Ribble Valley Borough Council  
Housing & Development Control

Your ref: 3/2022/1098  
Our ref: D3.2022.1098  
Date: 20<sup>th</sup> December 2022

Application no: **3/2022/1098**

Proposal: **Erection of proposed dwelling and creation of vehicle access.**

Drawing No. A200      Revision D  
51 Downham Road  
Date 30 Nov 2022      Drawn By      Check

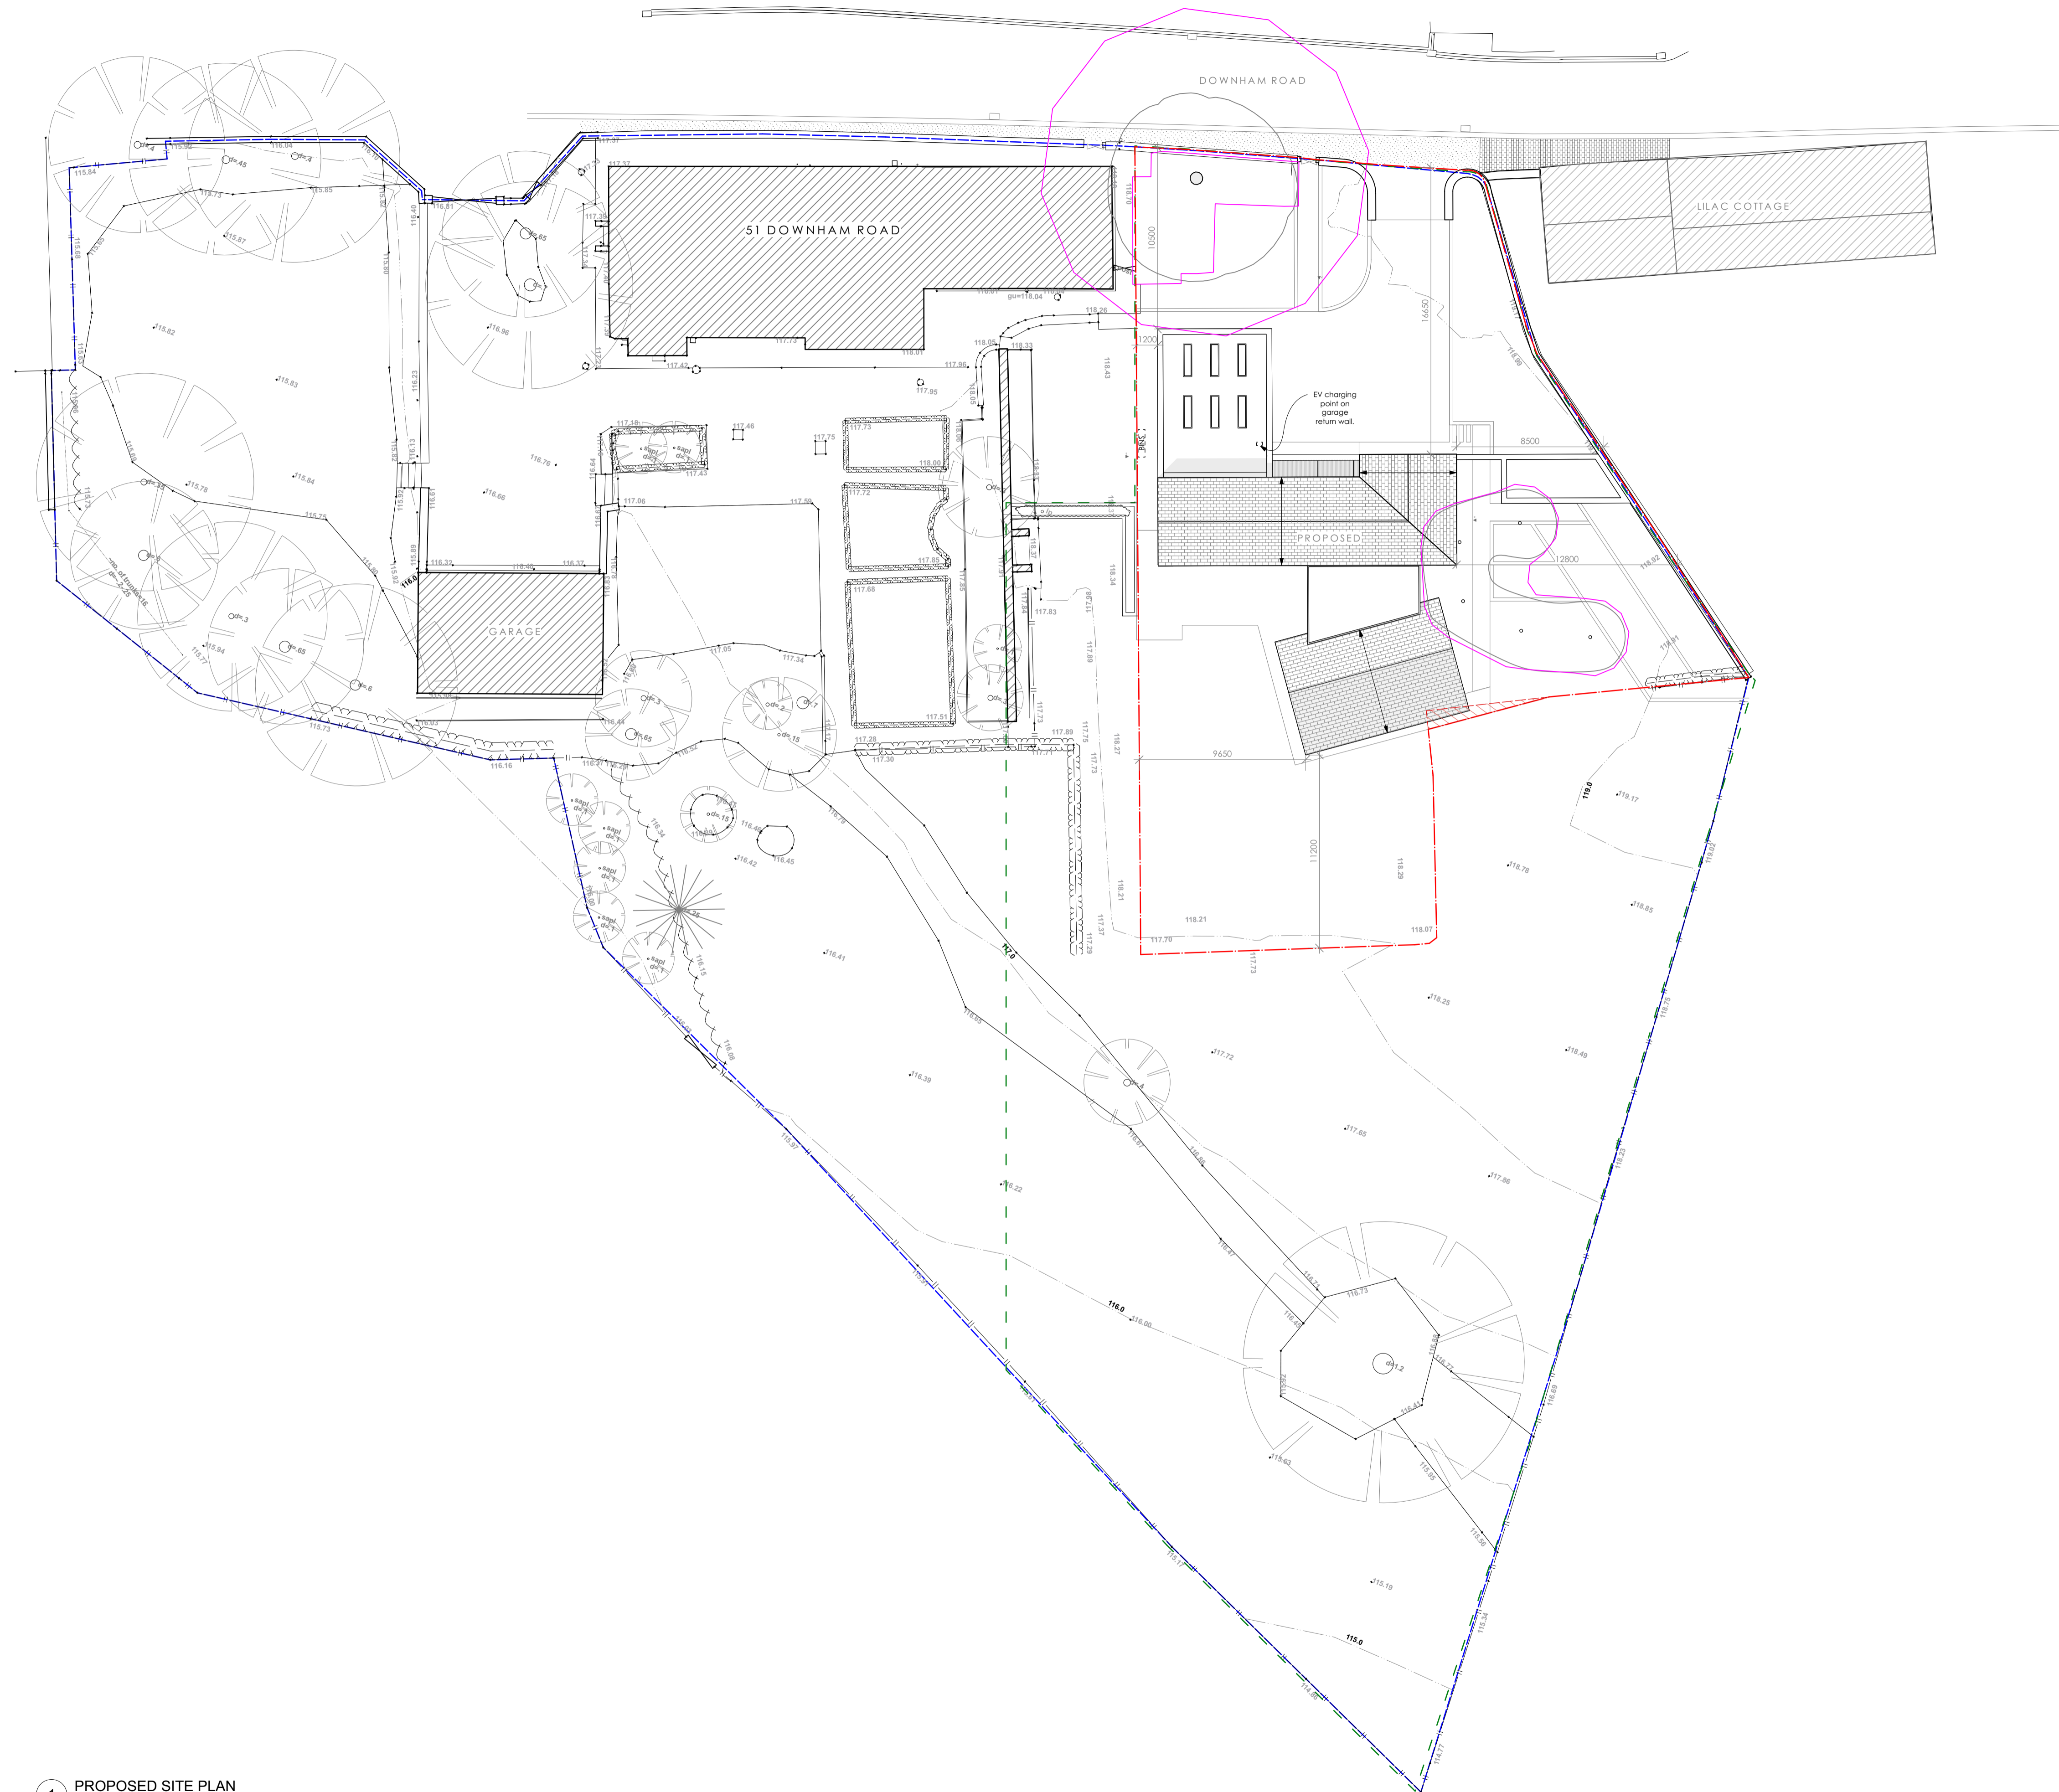
The LHA have reviewed Ivan Wilson drawing number A200 Rev D titled "Proposed Site Plan" and are aware that the access width complies with the LHAs guidance when serving a single dwelling.

The LHA will request, should the application be permitted, that the Applicant applies for a Section 278 agreement when creating the access. This is because the gully located at the access may need to be relocated which will be at the full cost of the Applicant. Please see the informative below for more information regarding the Section 278 agreement.

The LHA have reviewed Ivan Wilson drawing number A200 Rev D titled "Proposed Site Plan" and are aware that the site complies with the LHAs parking guidance as defined in the Joint Lancashire Structure Plan for the 4-bed dwelling. Therefore, the LHA have no objection to the proposal.

2. No part of the development hereby permitted shall be occupied until such time as the access arrangements shown on Ivan Wilson drawing number A200 Rev D have been implemented in full.

6. The development hereby permitted shall not be occupied until such time as the parking and turning facilities have been implemented in accordance with Ivan Wilson drawing number A200 Rev D. Thereafter the onsite parking provision shall be so maintained in perpetuity.
